23rd May 2013

Re: PLANNING APPLICATION EP/61/13NMA
BELTANE COURT, NURSERY CLOSE – (and other issues)

Drawing Title
Entrance gates and railings

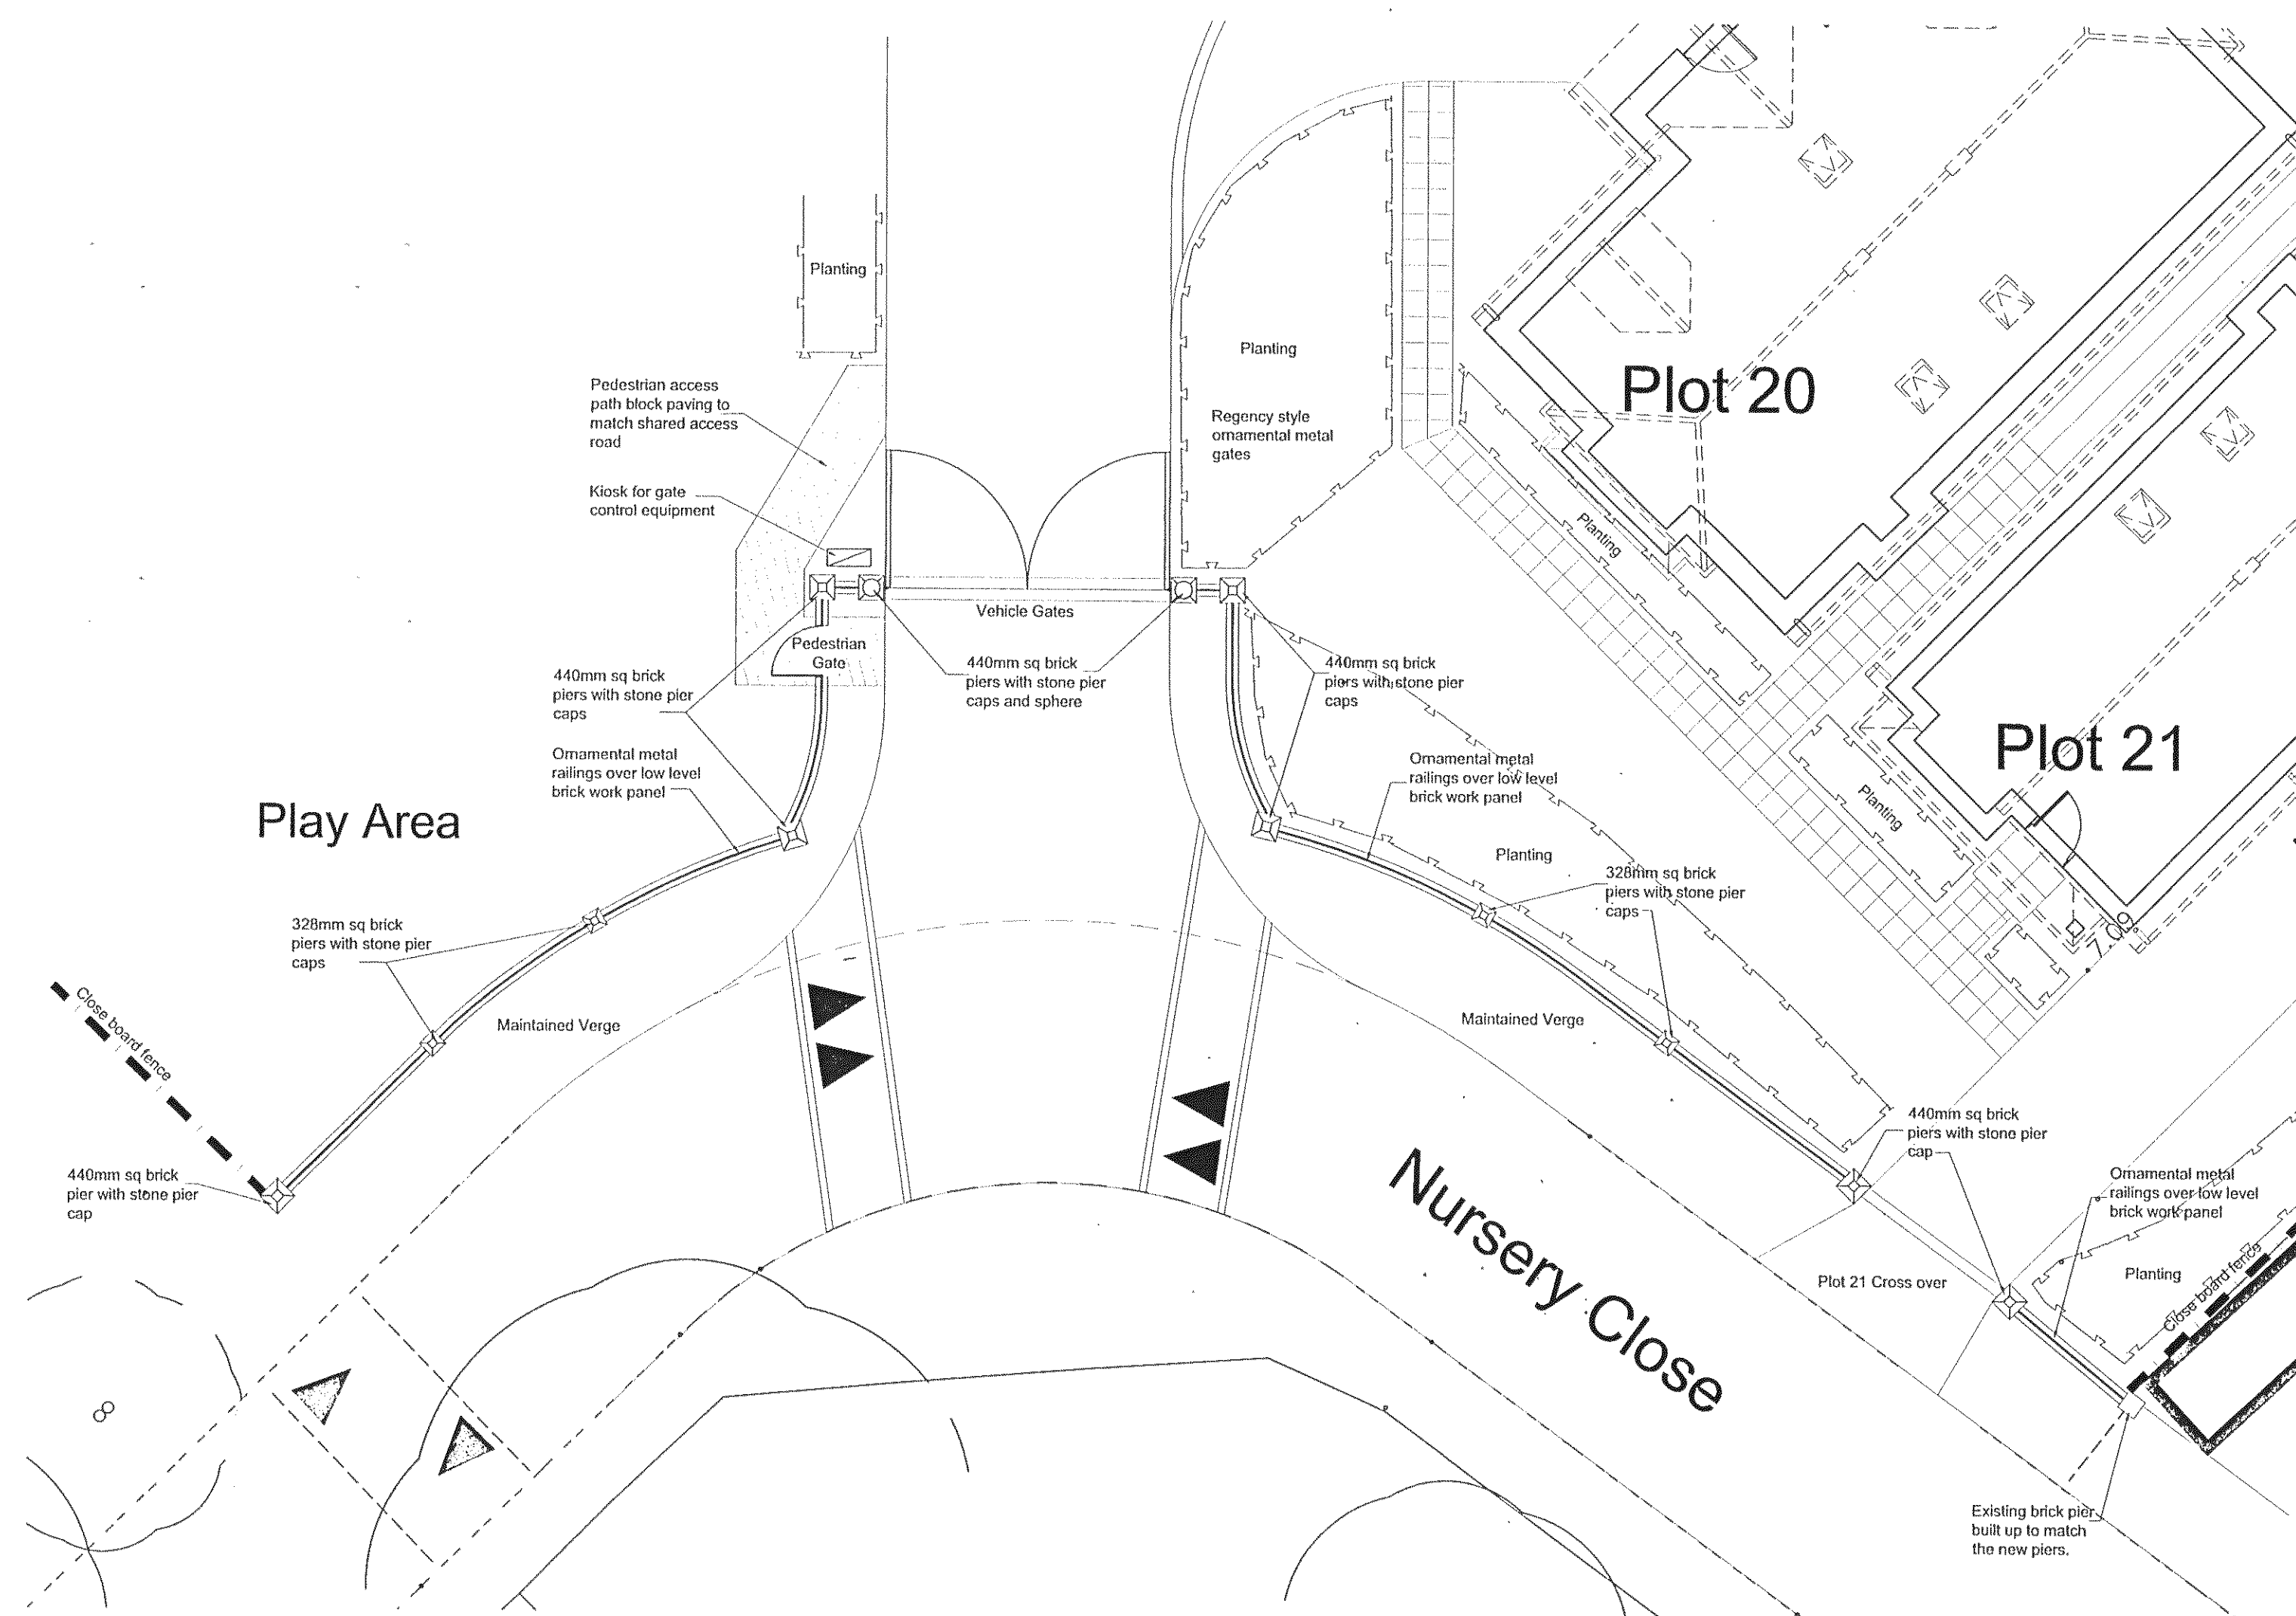
On reading your email re the above proposed gates and walls I would respond in the following manner. I believe the gates were proposed in the original plan and possibly the walls, but not in any great detail. In principle I do not object to the walls or gates but feel the plans do not clearly state the height of the proposed wall, therefore it is difficult to ascertain whether it will be overbearing or not.
